Our Case Number: ABP-314056-22

Re: Liffey Valley to City Centre Core Bus Corridor Scheme.
Fonthill Road to High Street all in the County of Dublin.

Dublin Cycling Campaign

Liffey Valley to City Center Core Bus Corridor (Case: 314056)

Programme Title: <b>BUSCONNECTS DUBLIN CORE BUS CORRIDORS INFRASTRUCTURE WORKS</b>			
Drawing Title: LIFFEY VALLEY TO CITY CENTRE CORE BUS CORRIDOR SCHEME GENERAL ARRANGEMENT			
Drawing File Name: BCIDB-JAC-GEO_GA-0007_XX_00-DR-CR-0027	Sheet Number: 27 of 28	Status: A	Rev: M01

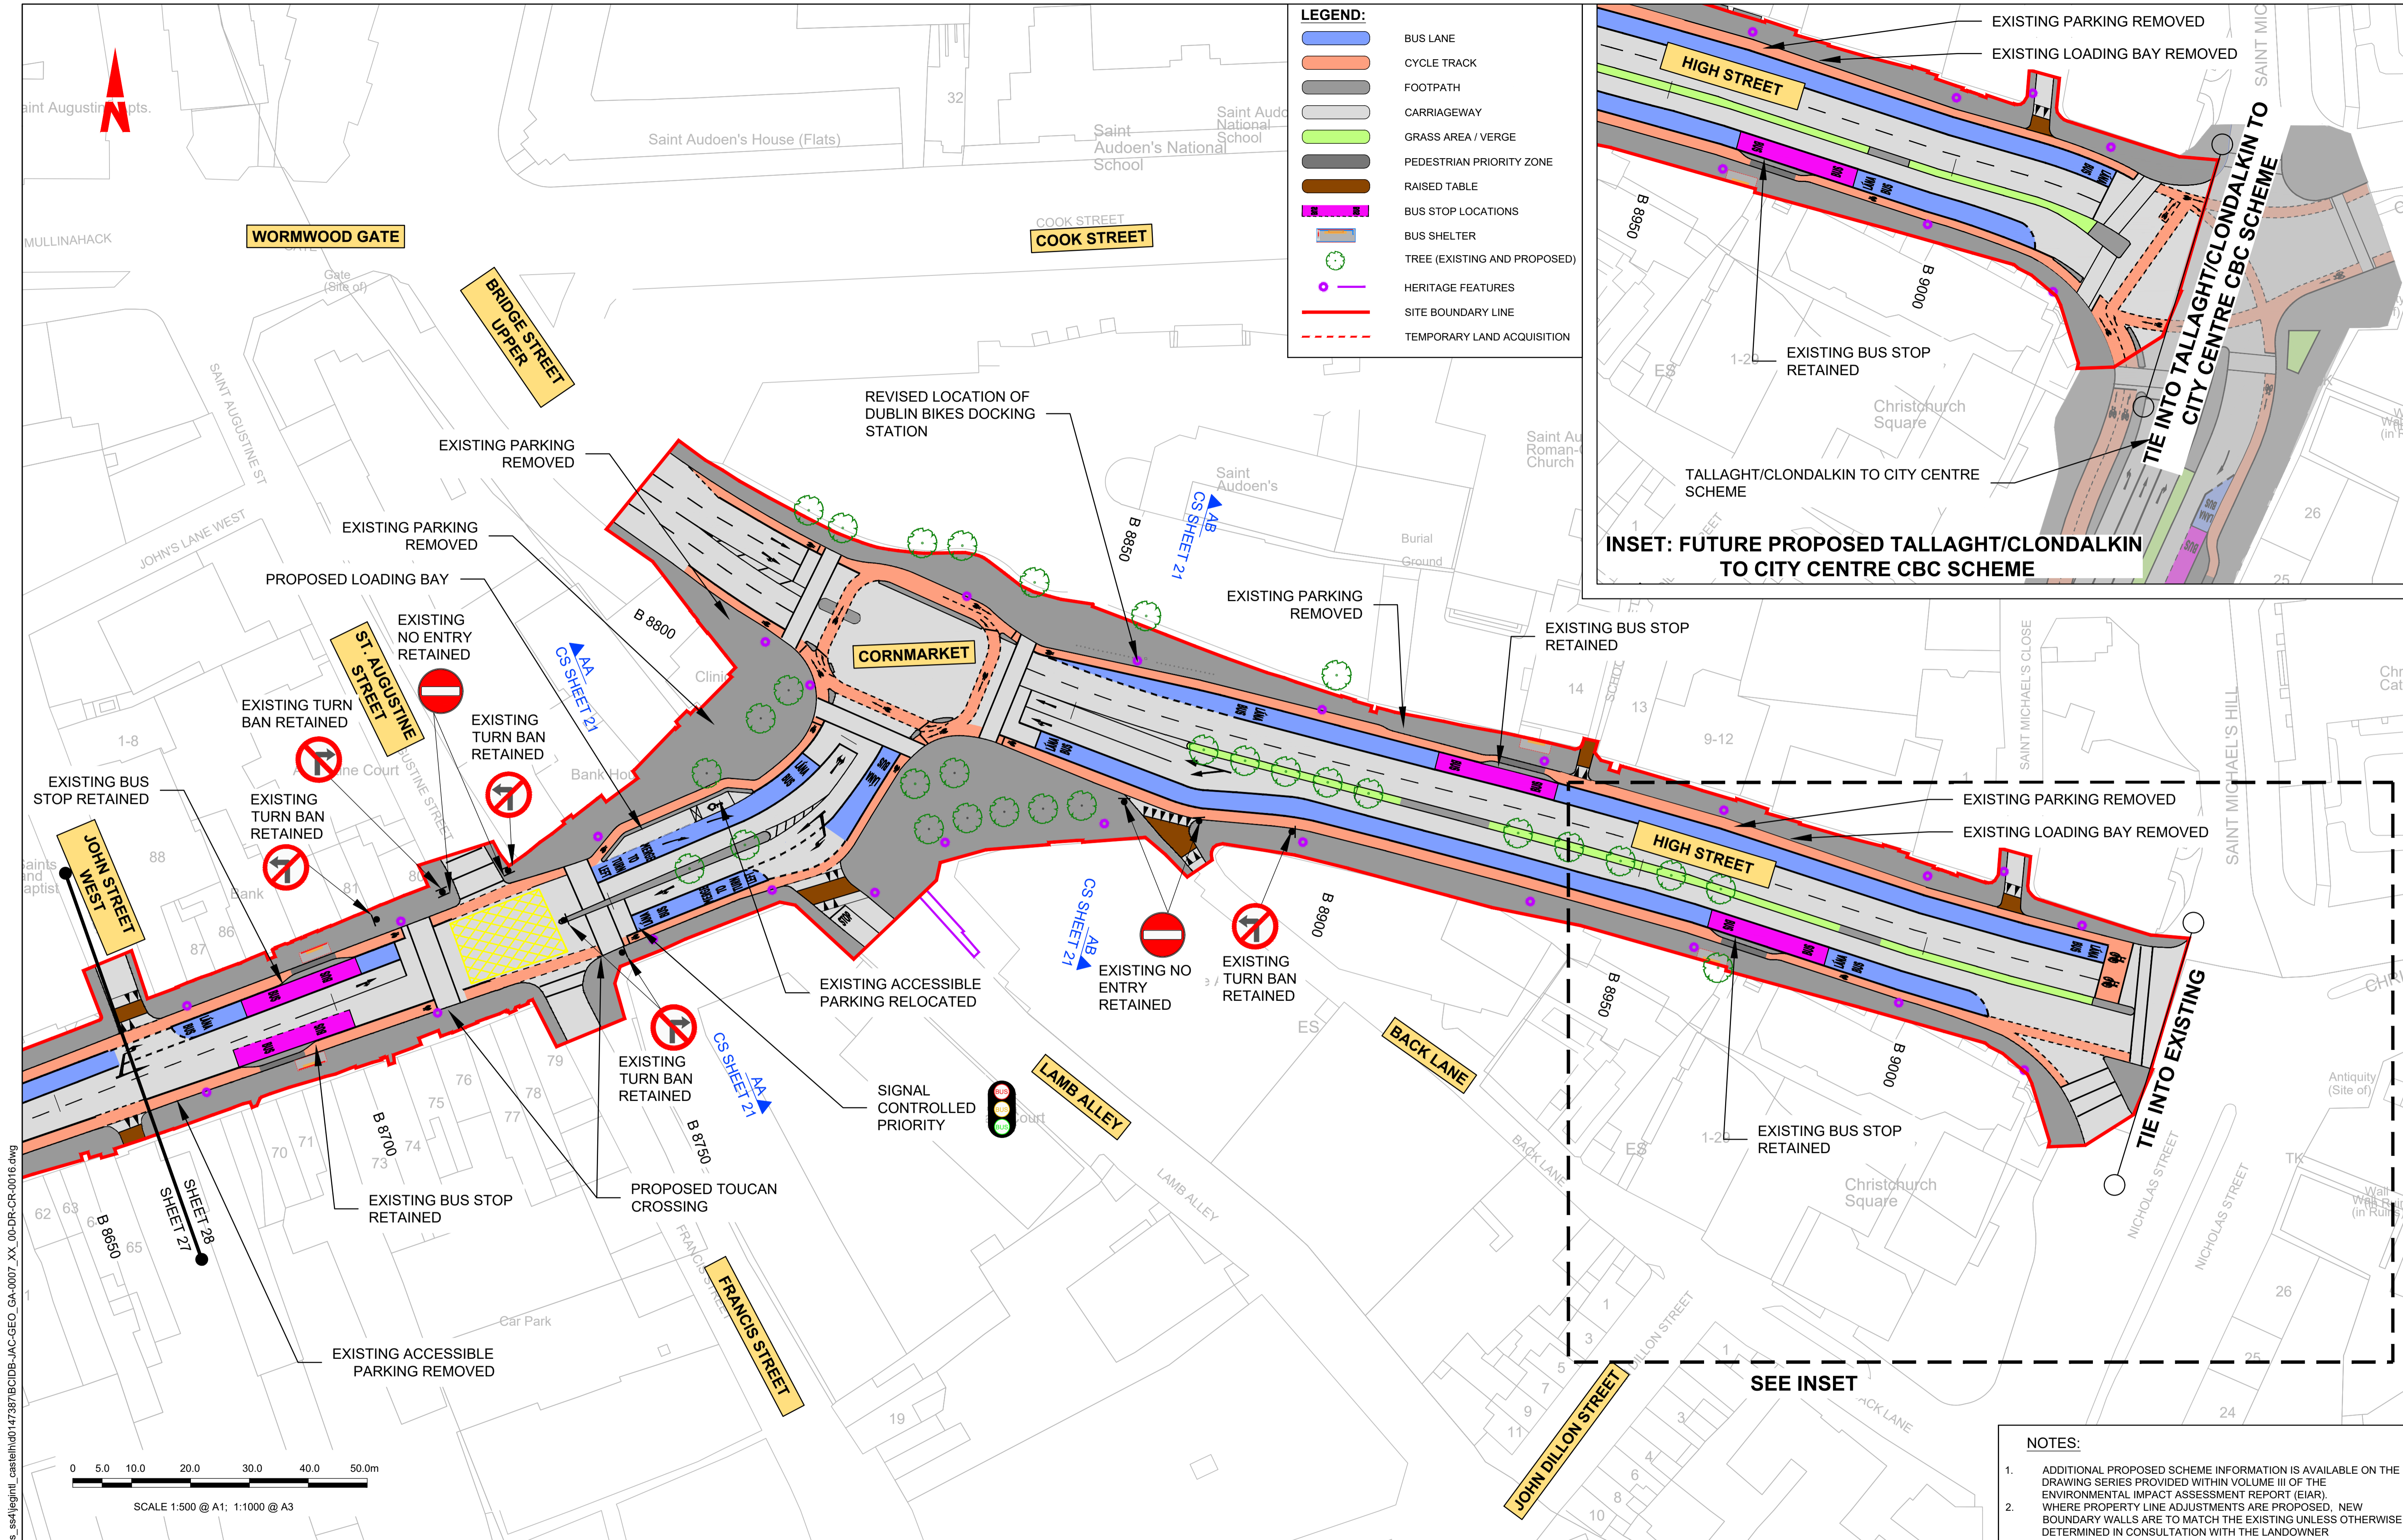
High Street (general arrangement drawings sheet 28) includes space for multiple general traffic lanes but provides sub-standard width cycle tracks. There are a limited number of cross-sections in this area but cycle tracks are below the 2m standard width for long sections of this street. The cycling campaign accepts the need to narrow cycle tracks in some areas where space is limited, however on High Street space isn't limited. High Street is one of the widest streets along the entire corridor and even here the cycle tracks are being narrowed to provide a second general traffic lane.

High Street is identified as primary cycle route 7 in the NTA's Greater Dublin Area Cycle Network Plan (2013). Primary cycle routes are the main cycle routes for the network; they aim to provide a higher level of service, as defined by the National Cycle Manual (NCM), than other identified routes.

The proposed width of these cycle lanes would only achieve a quality of service Level D (NCM pg 10), far below the expectations for a primary cycle route.

Is it accepted public policy to provide multiple traffic lanes for private cars before providing adequate space for cycling at key city center locations?

We request: that the second general traffic lane be removed to provide adequate space for people cycling along this key city center cycling link.
